**KIRKLEES METROPOLITAN COUNCIL  
INVESTMENT & REGENERATION SERVICE**

**DELEGATED DECISION TO DETERMINE PLANNING APPLICATIONS**

Reference No:	<b>2025/62/91398/W</b>
Site Address:	Well Pharmacy, 63, Market Street, Milnsbridge, Huddersfield, HD3 4HZ
Description:	Erection of extension and alterations to form 3 apartments (within a Conservation Area)
Recommending Officer:	Danielle Cooper

**DECISION – Full Conditional Permission**

Rear Elevation West
1 : 100

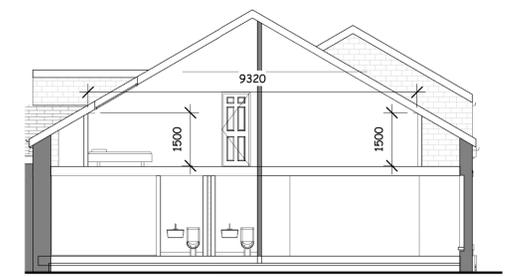
A roof extension is proposed to the existing two storey rear element to improve functionality of flat 1. The extension will feature a pitched roof which is the same height as the adjacent adjoining buildings rear extension. The eaves will sit below the eaves of the main building. The extension will be constructed from matching stone and slate roof tiles. A first-floor rear window is proposed.

The agent revised the roof form the rear extension.

A roof extension is proposed to the existing two storey rear element to improve functionality of flat 1. The extension will feature a pitched roof which is the same height as the adjacent adjoining buildings rear extension. The eaves will sit below the eaves of the main building. The extension will be constructed from matching stone and slate roof tiles. A first-floor rear window is proposed. The proposed extension is considered to keep in character with that of the host building in regard to design and materials. As such the proposed extension is considered visually acceptable and will respect the character and appearance of the host building and conservation area. However, in the event that planning permission be approved, a condition is recommended to ensure the materials of the proposed extension match those of the existing building.

Proposed First Floor Plan
1 : 50

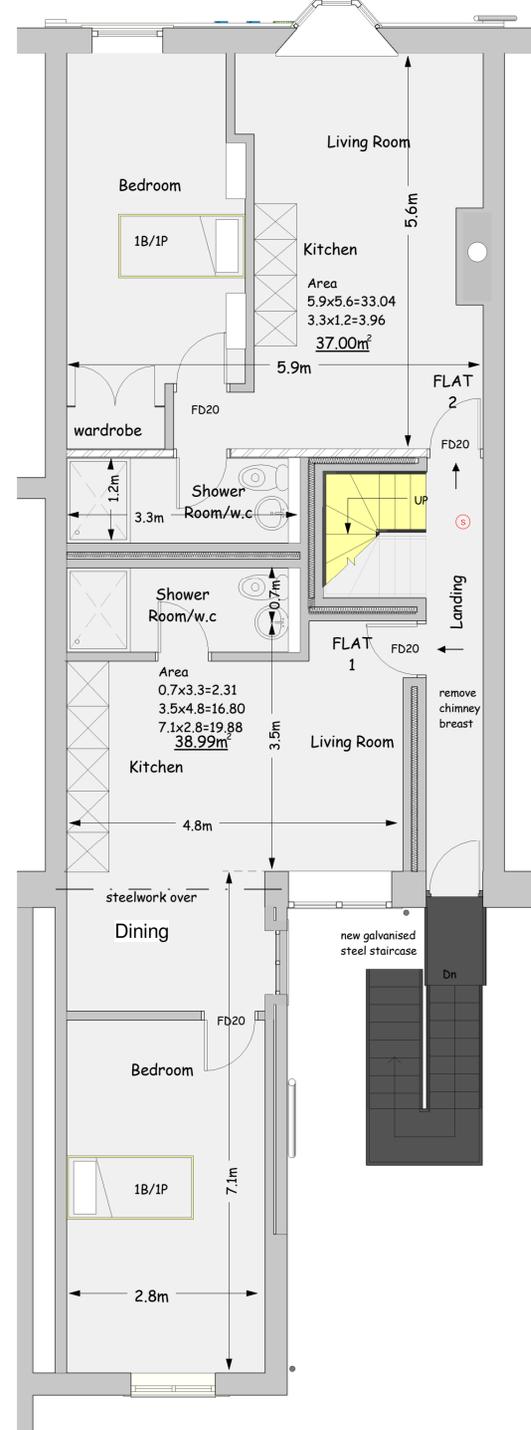
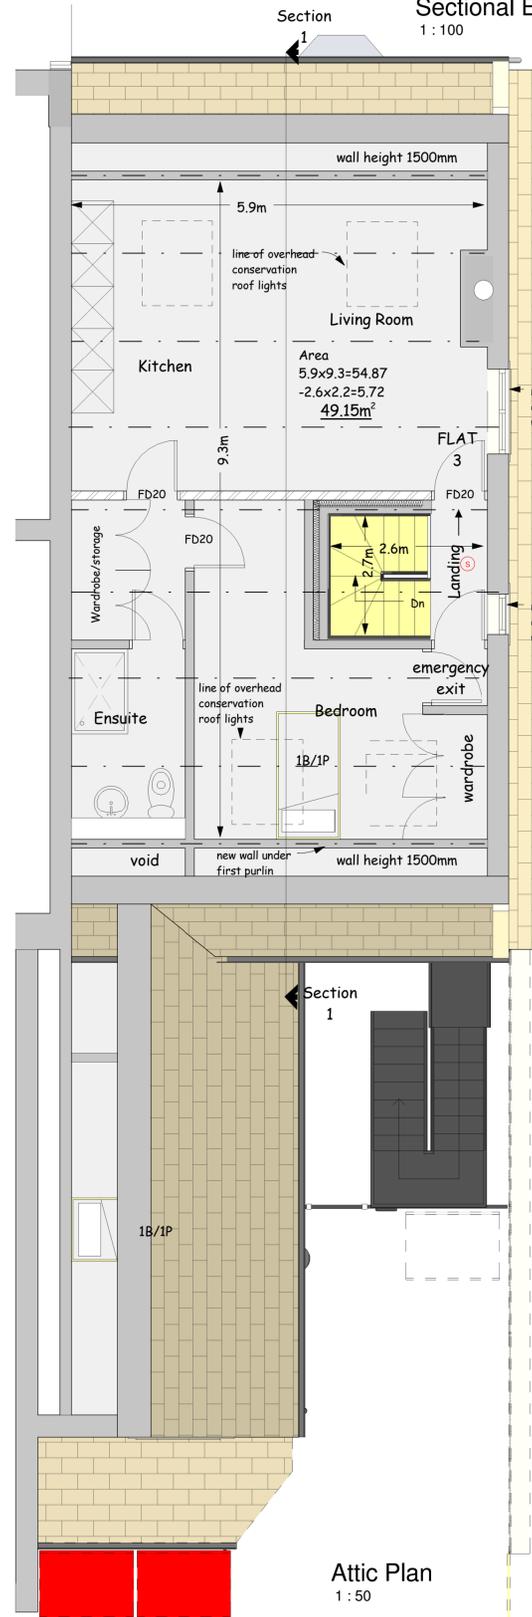
Concern was raised in regard to the proposed flats falling short of the required national minimum space standards (NDSS). The agent has confirmed that all flats will be 1 bed and 1 person, meeting the required national minimum space standards.

Where a 1b1p has a shower room instead of a bathroom, the floor area may be reduced from 39m<sup>2</sup> to 37m<sup>2</sup>. The agent has confirmed via email that all flats will be 1bed/1person, and revised plans have been received to evidence a one bed/person in each flat.
